A. R. ROBINSON
Dip. Arch. (Dunelm), A.R.I.B.A. (Rtd.)
14 MANDEVILLE RISE
WELWYN GARDEN CITY
HERTFORDSHIRE
AL8 7JU

19. 11. 2013

RE: N6/2013/1938/MA AMENDED PROPOSED ALTERATIONS TO CAMPUS EAST

Title Proposed Materials

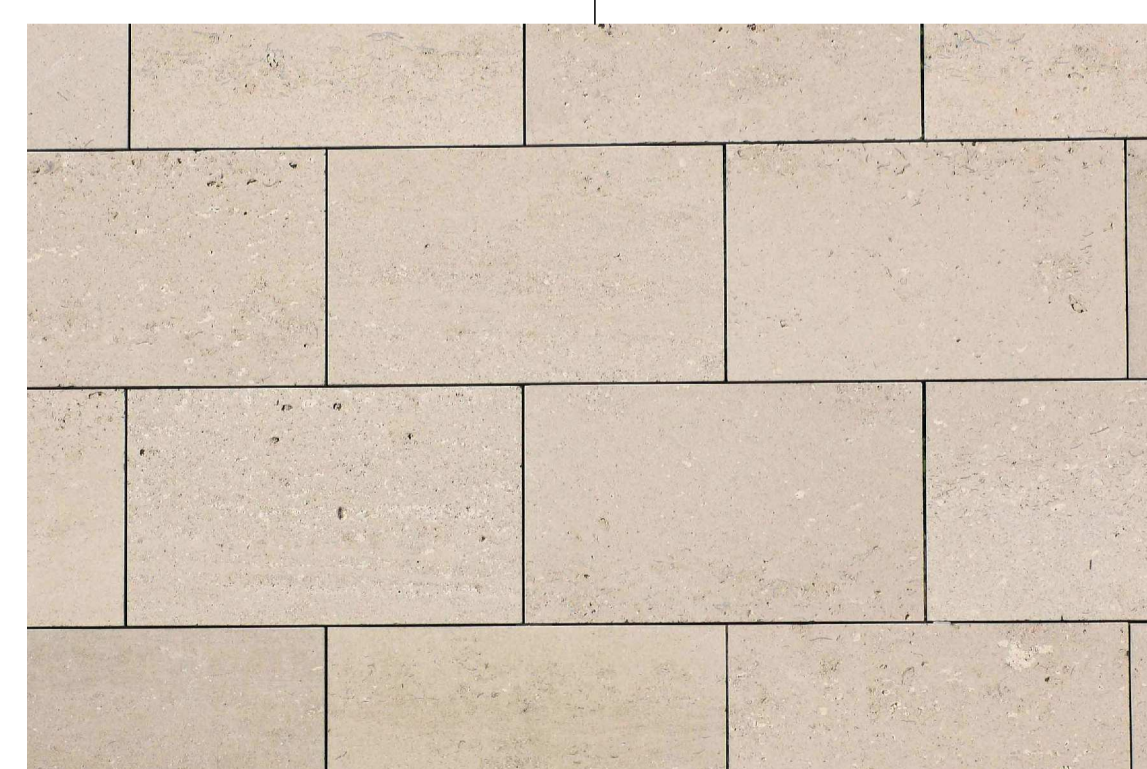
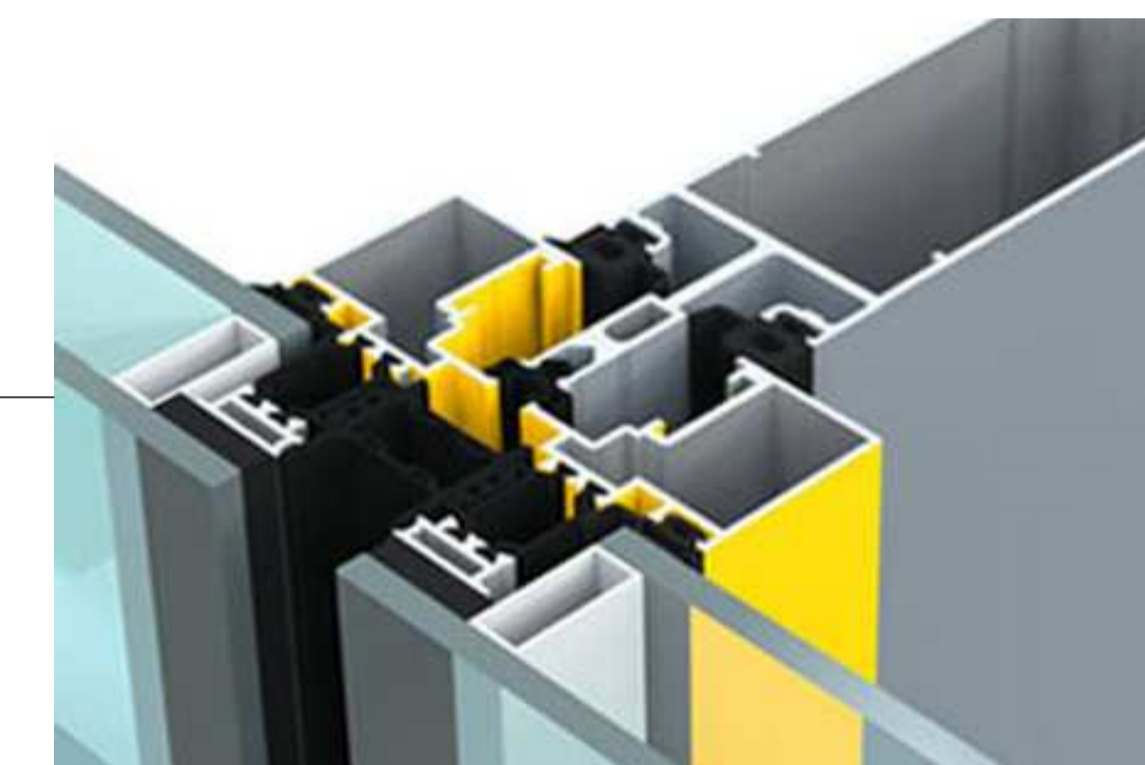
The amended architectural treatment using brick either side of the arch suggests that the whole of the new elevation should be treated with this material and the proposed arch be abandoned.

Title Proposed Entrance to
Council Chamber
Large Stone Surround
Detail Drawing

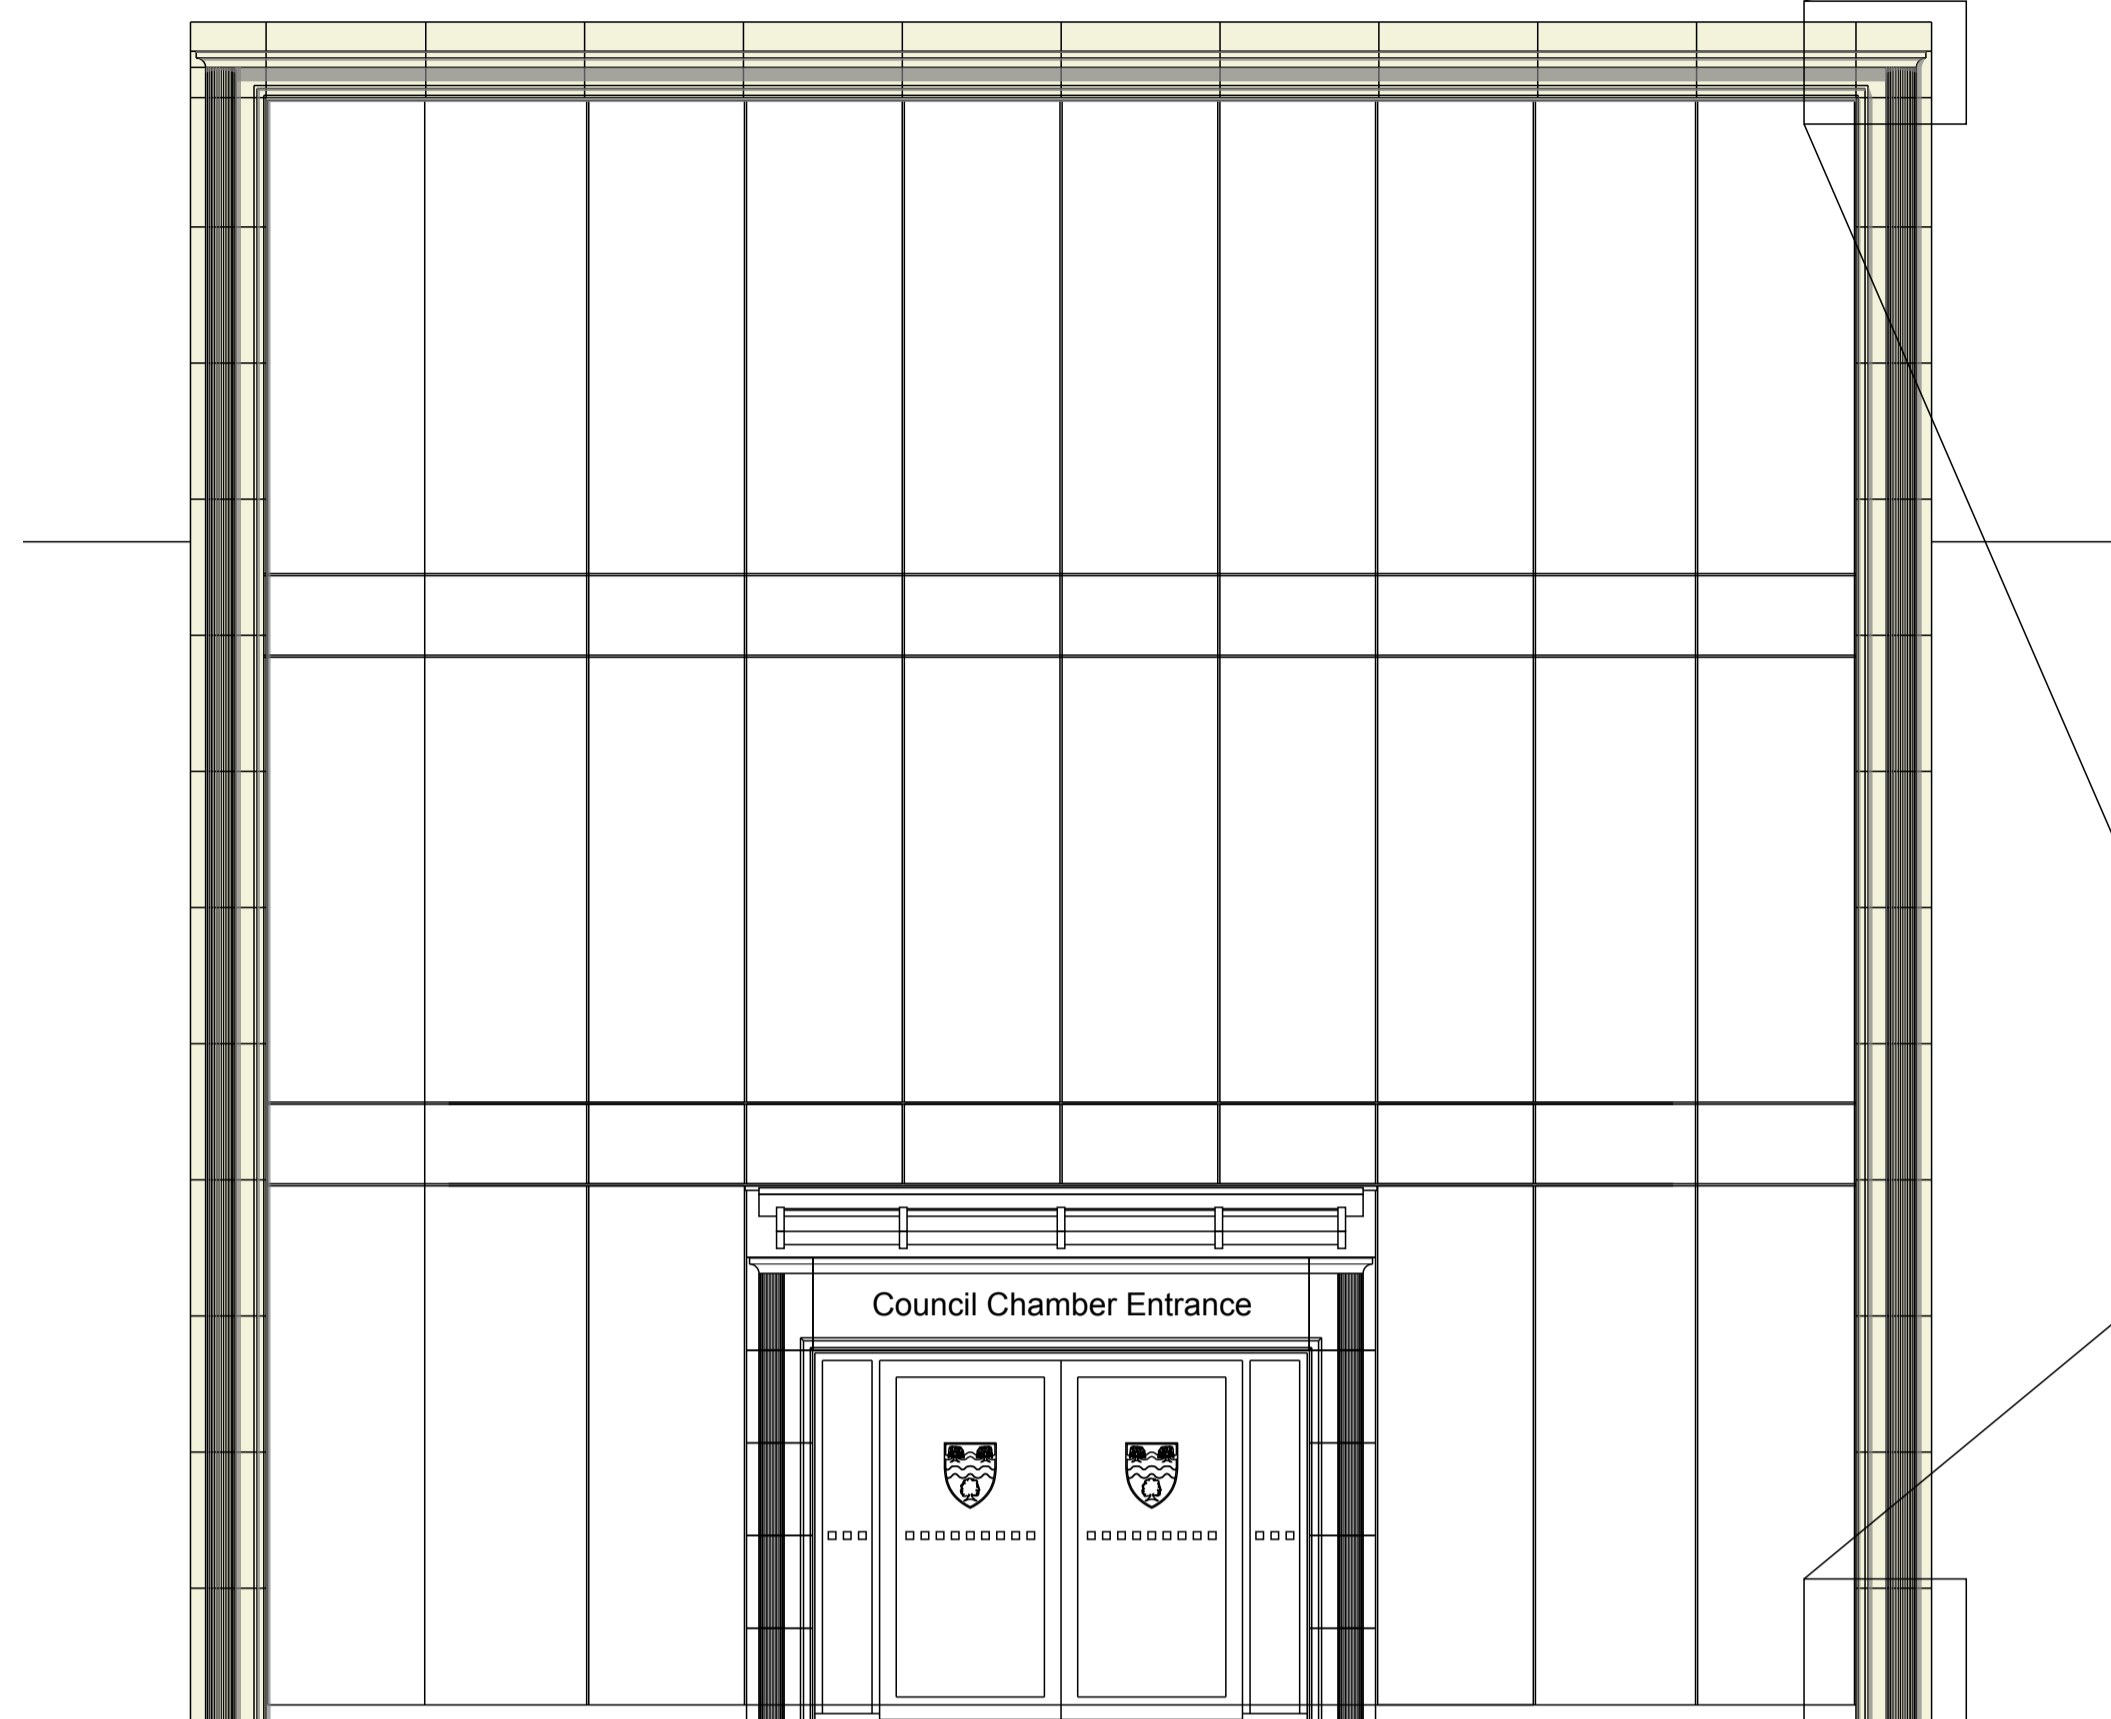
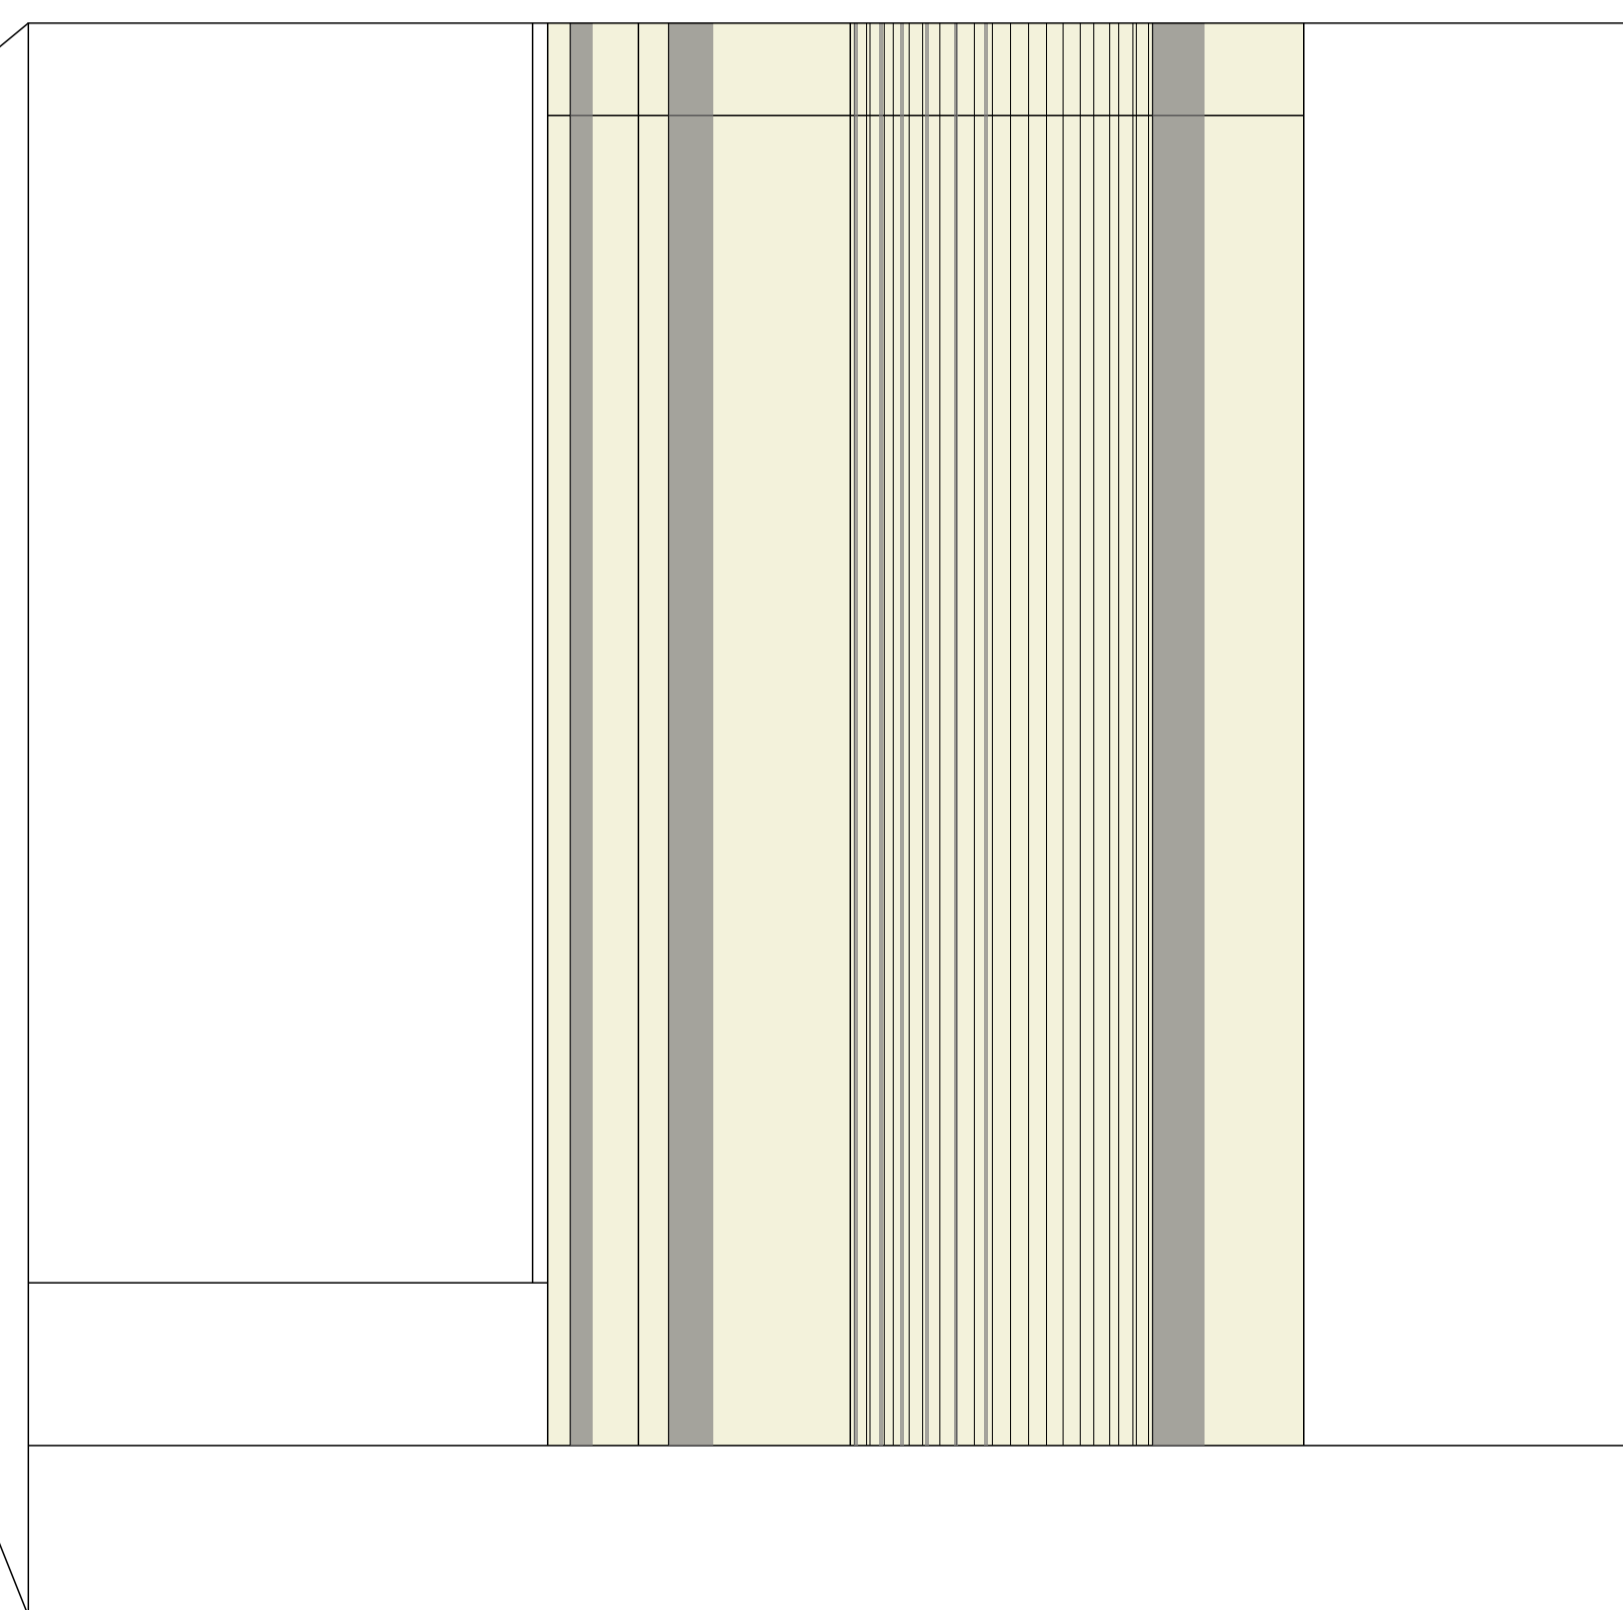
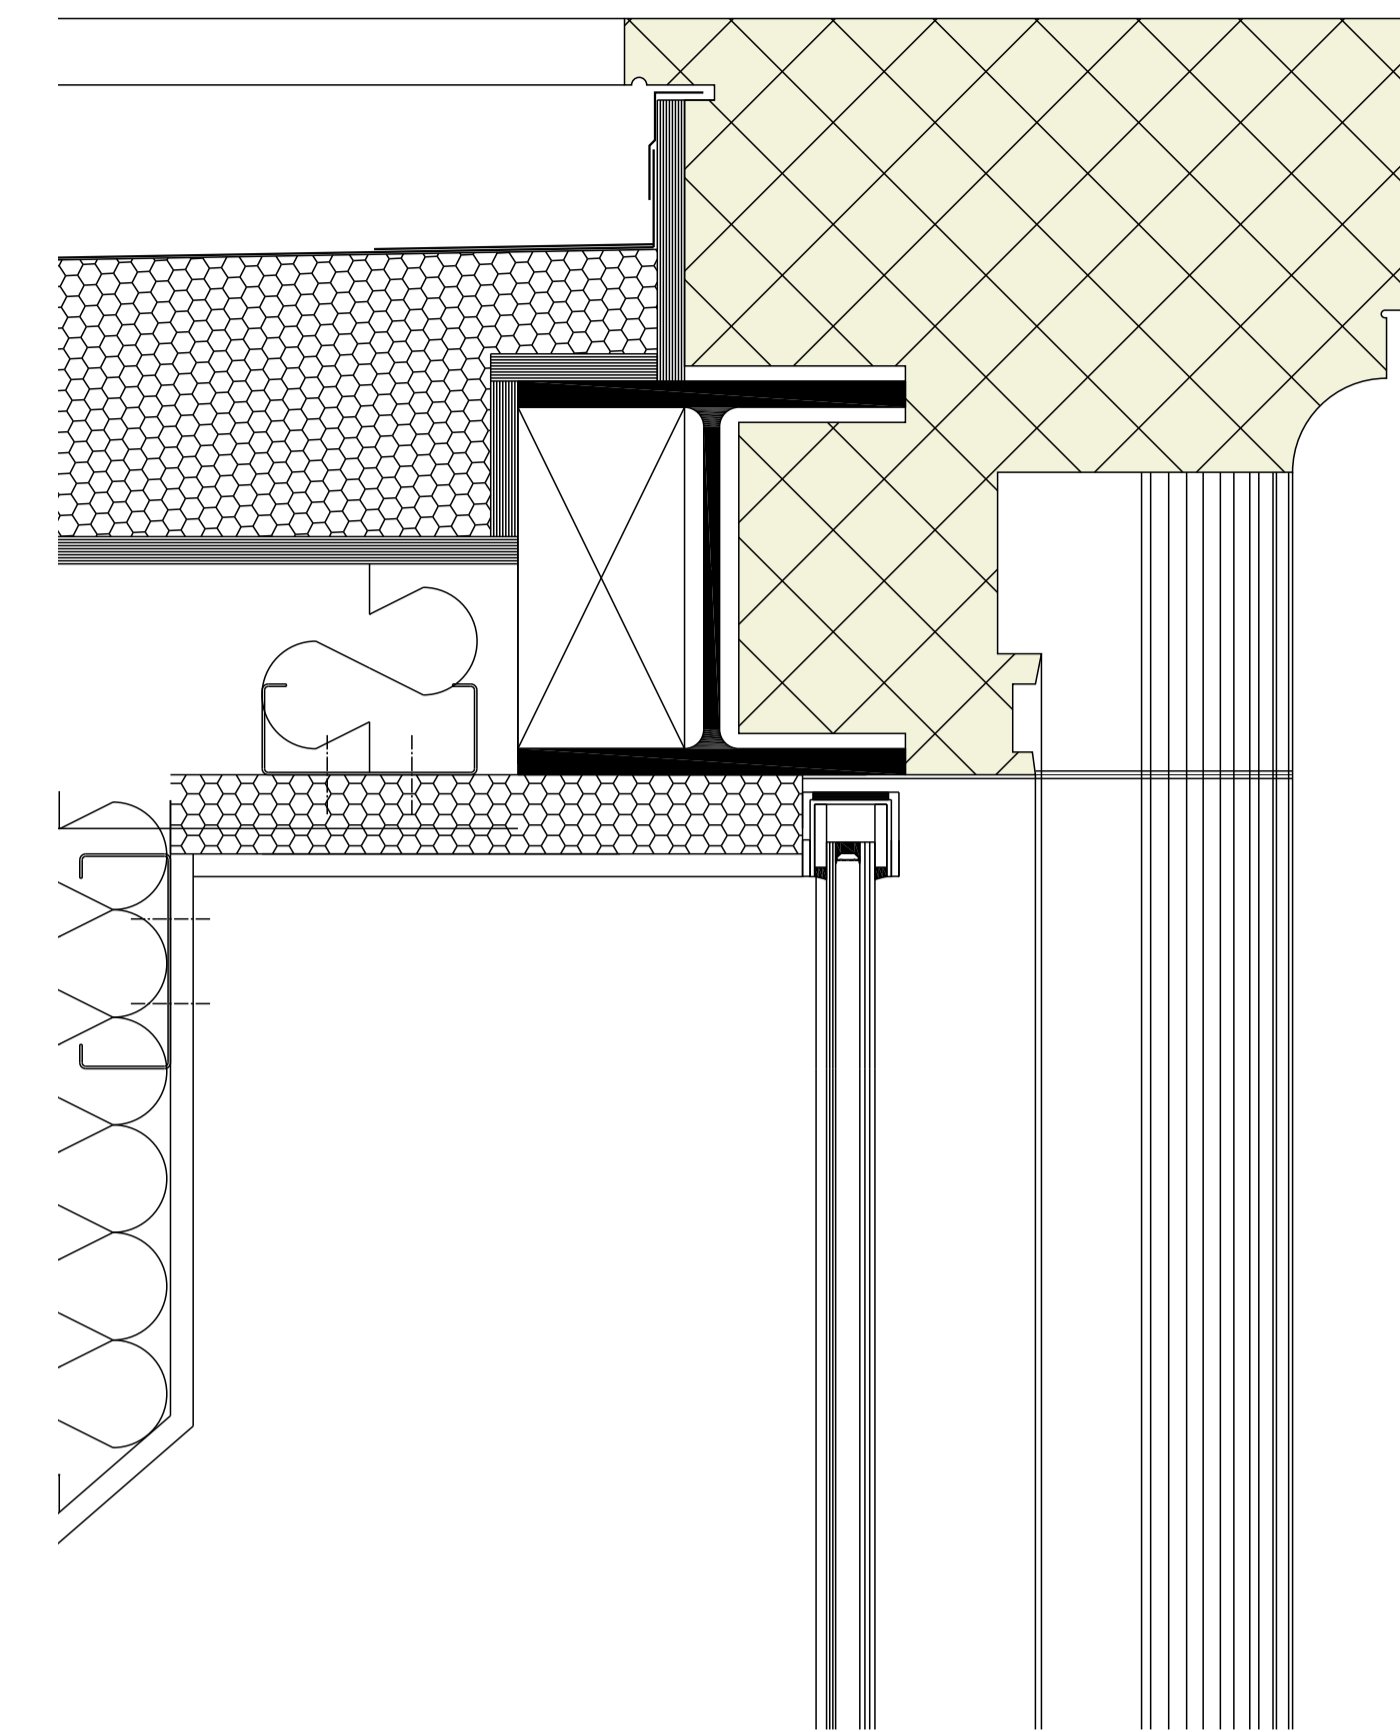
Having been informed by WHC staff that the plans have not been amended, the principal features of the design, namely the Council Chamber and the proposed arch do still not align.

The fact that the elevations of the existing wings are not symmetrical should not impose symmetry on the new elevation.

I therefore object to the amended proposal.
